FOURSQUARE AT STERLING RANCH EAST FILING NO. 1

A PORTION OF SECTIONS 33 AND 34, TOWNSHIP 12 SOUTH,
RANGE 65 WEST OF THE SIXTH PRINCIPAL MERIDIAN,
EL PASO COUNTY, COLORADO

v2_Final Plat Drawings.pdf Markup Summary 4-24-2023

FOURSQUARE AT STERLING RANCH EAST FILING NO. 1
 JOB NO. 1183.23
 NOVEMBER 9, 2022
 SHEET 1 OF 6

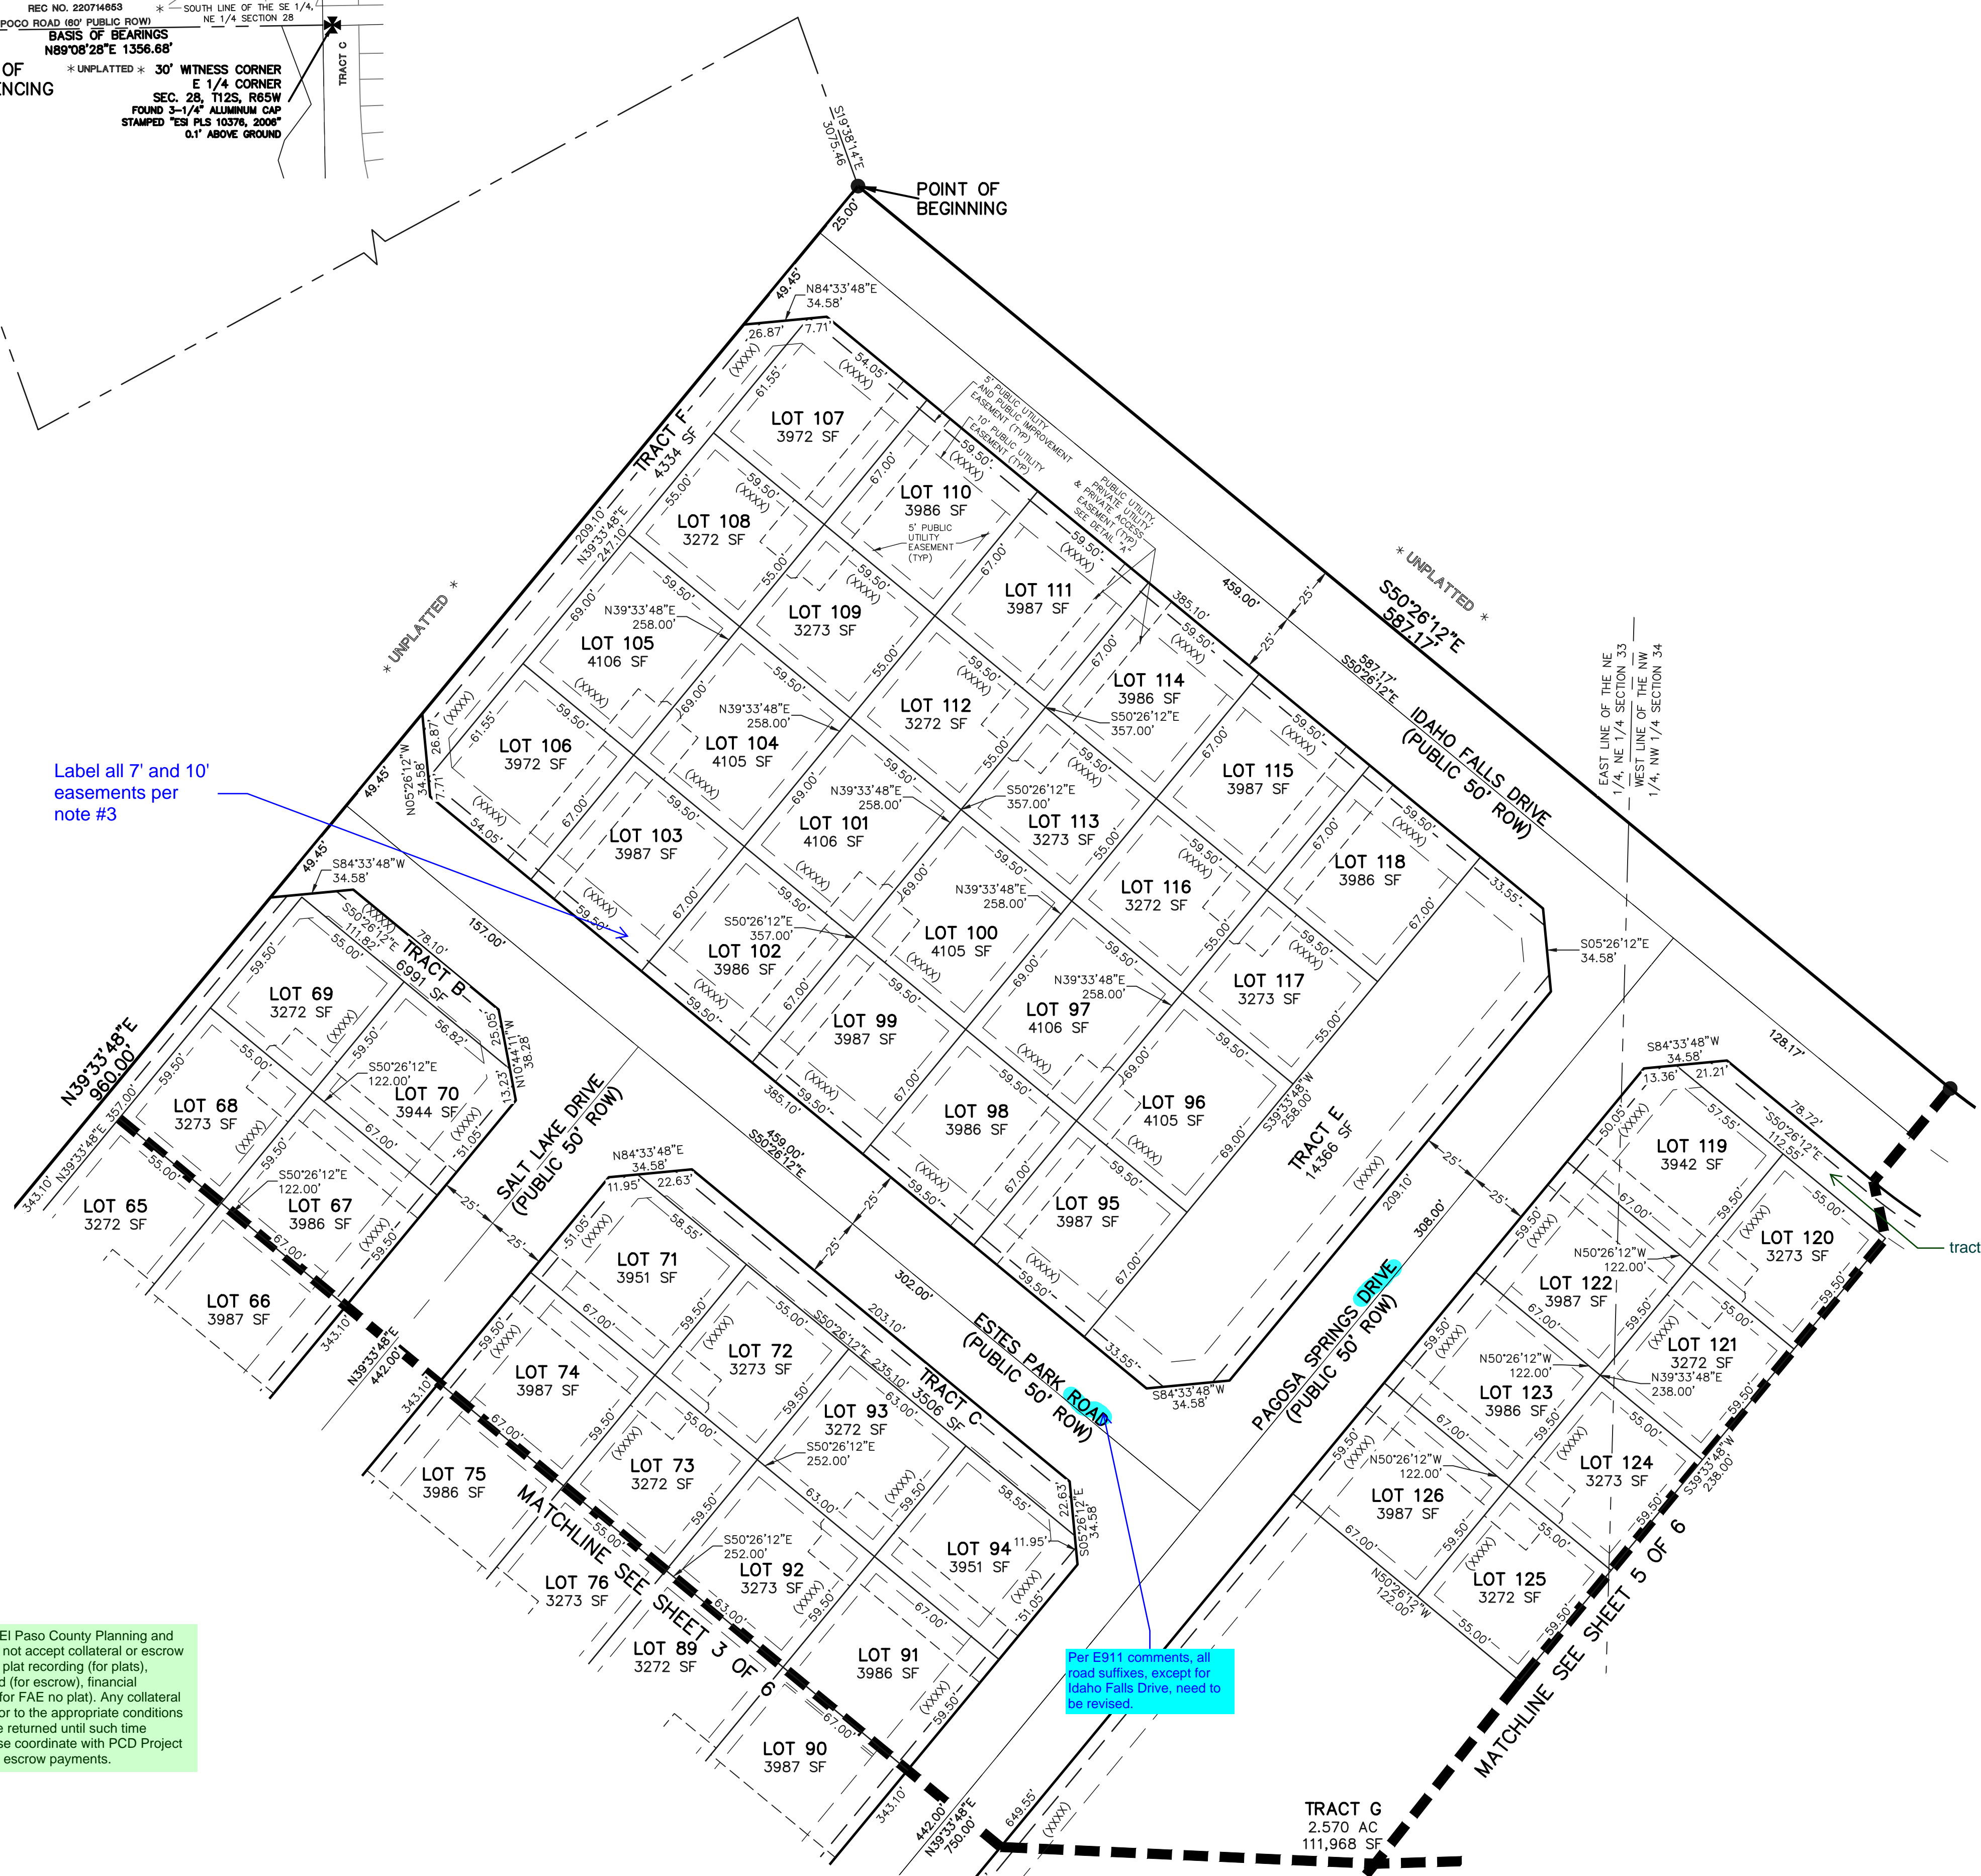
Please add this note carried over from PUDSP (repeat comments)

Add dollar amounts at Mylar

In lieu of depicting trails; add the note that identifies the trails in the tracts, and, adjacent to lots ; Tract I is not the only trail tract (repeat comment)

Add stormwater/drainage

FOURSQUARE AT STERLING RANCH EAST FILING NO. 1
JOB NO. 1183.23
NOVEMBER 9, 2022
SHEET 5 OF 6

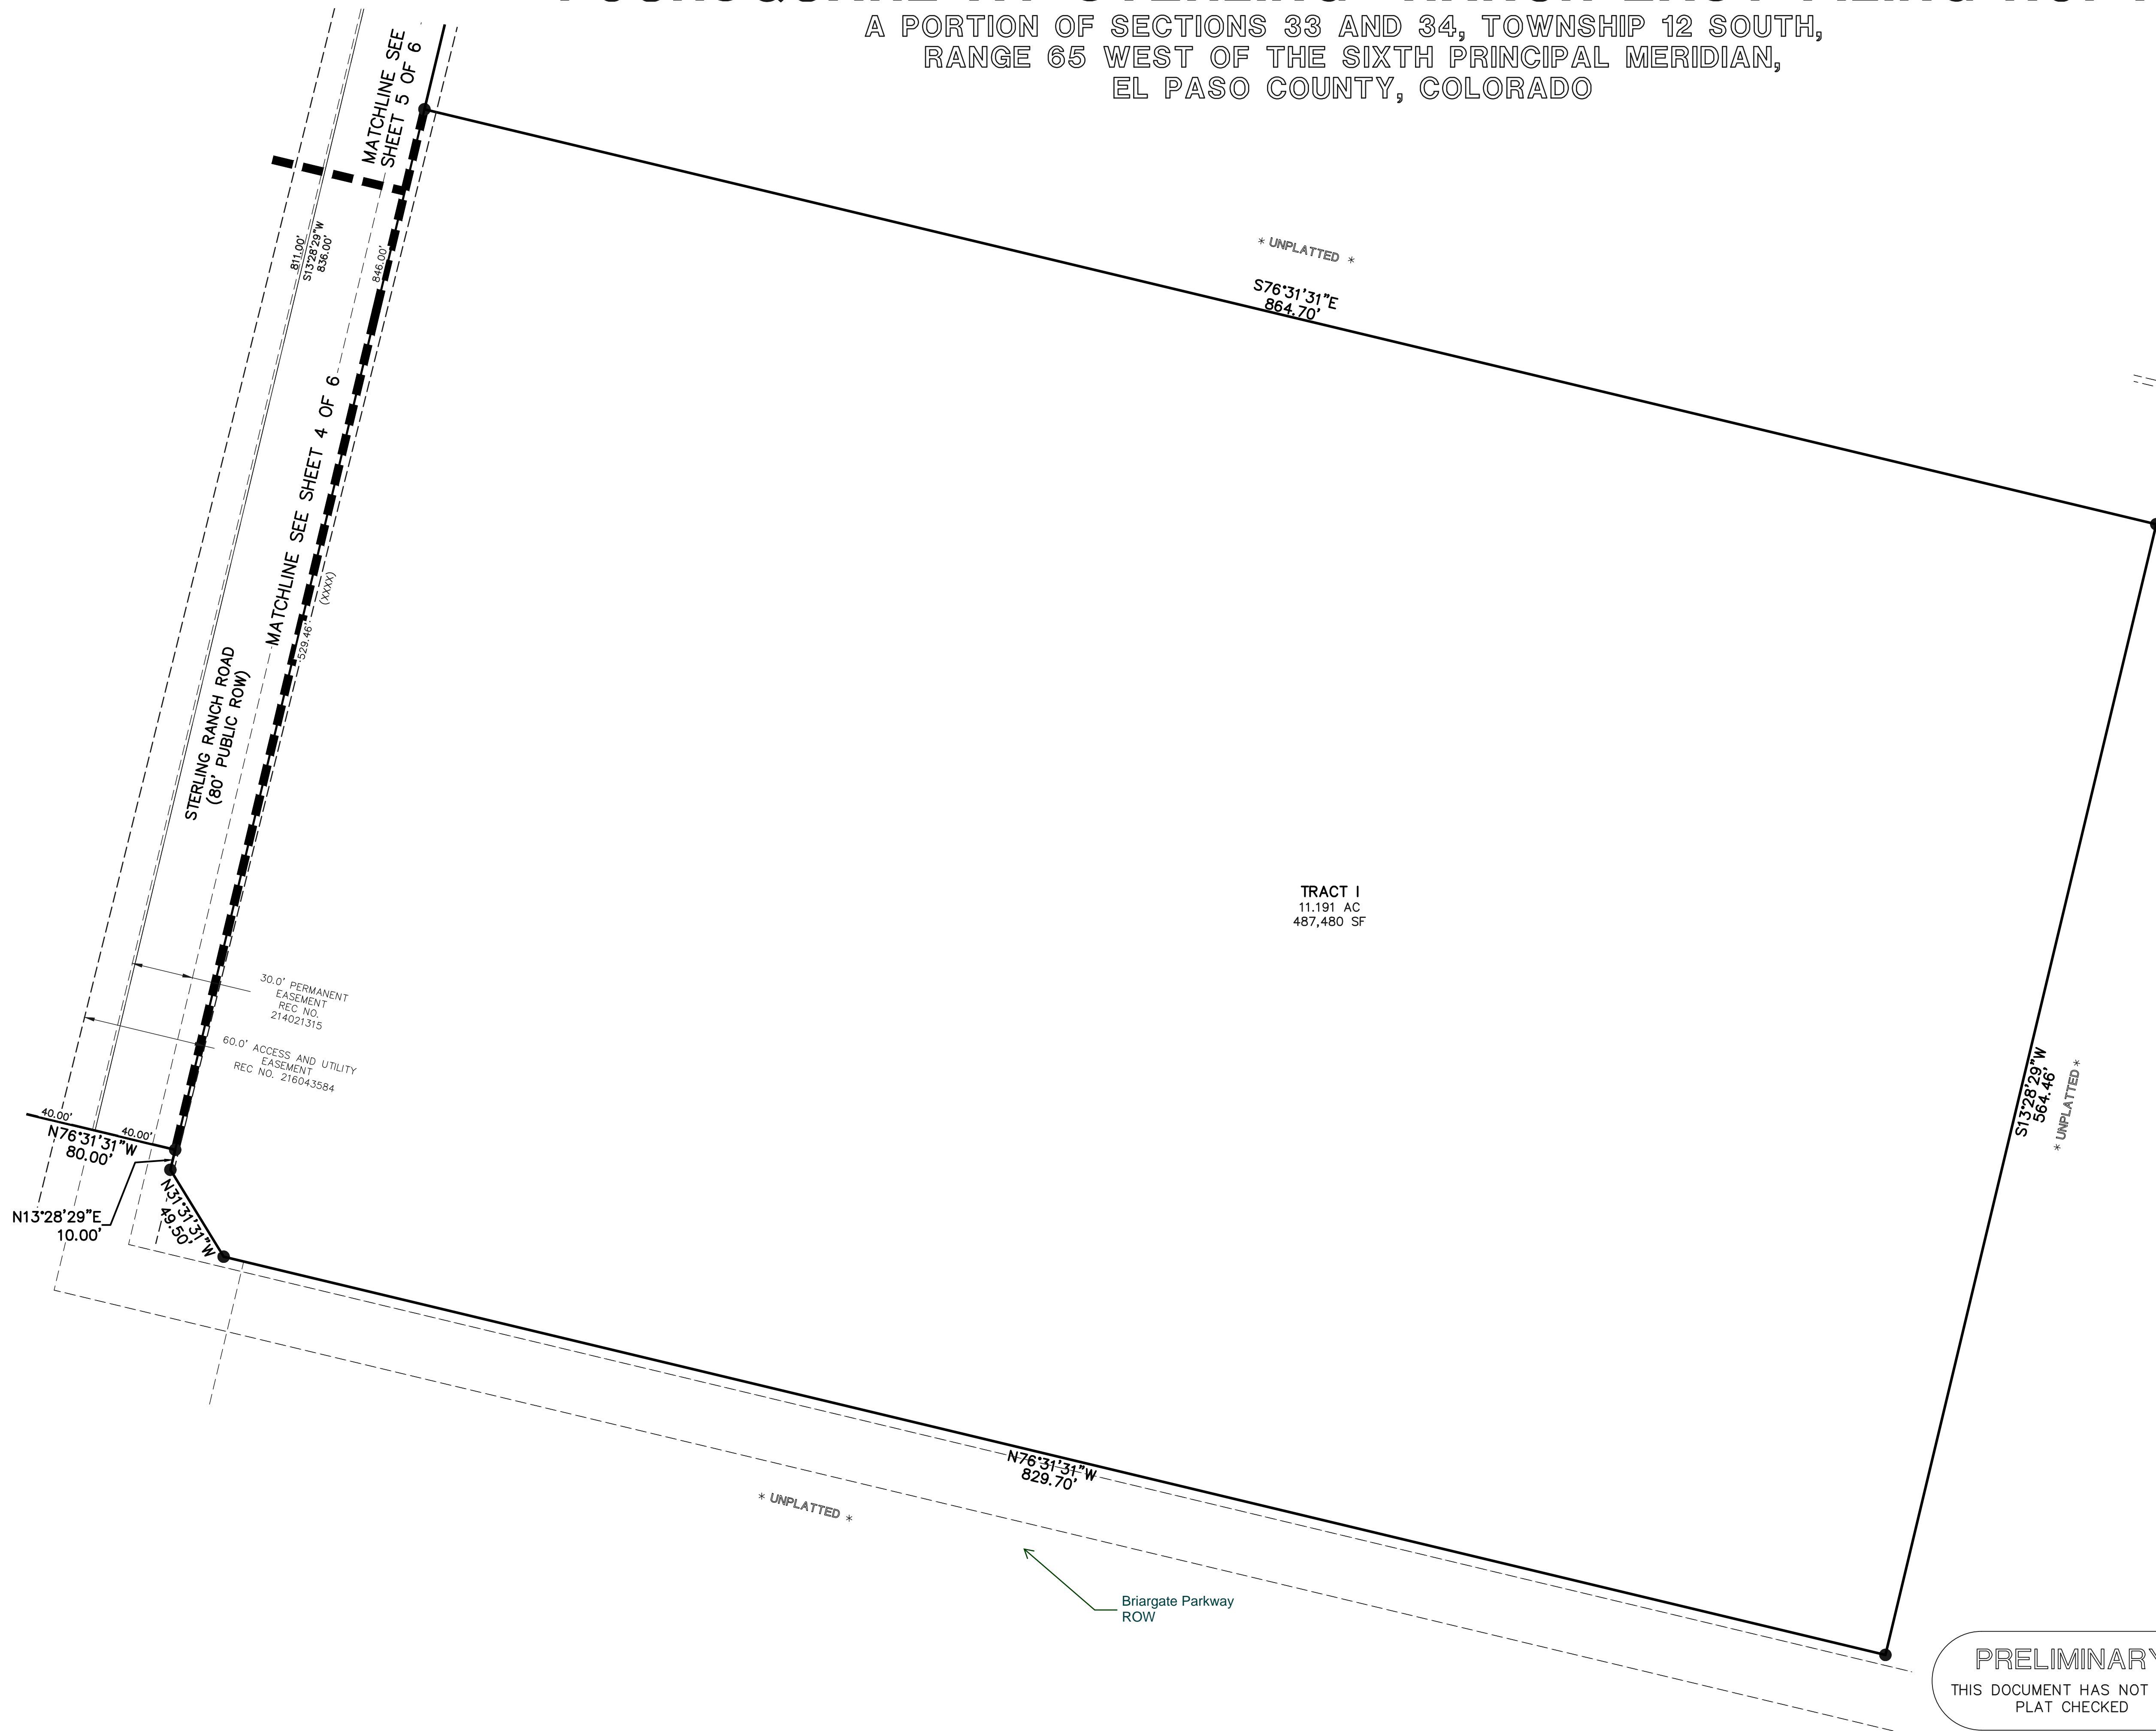
Show PIE easements along ROWs
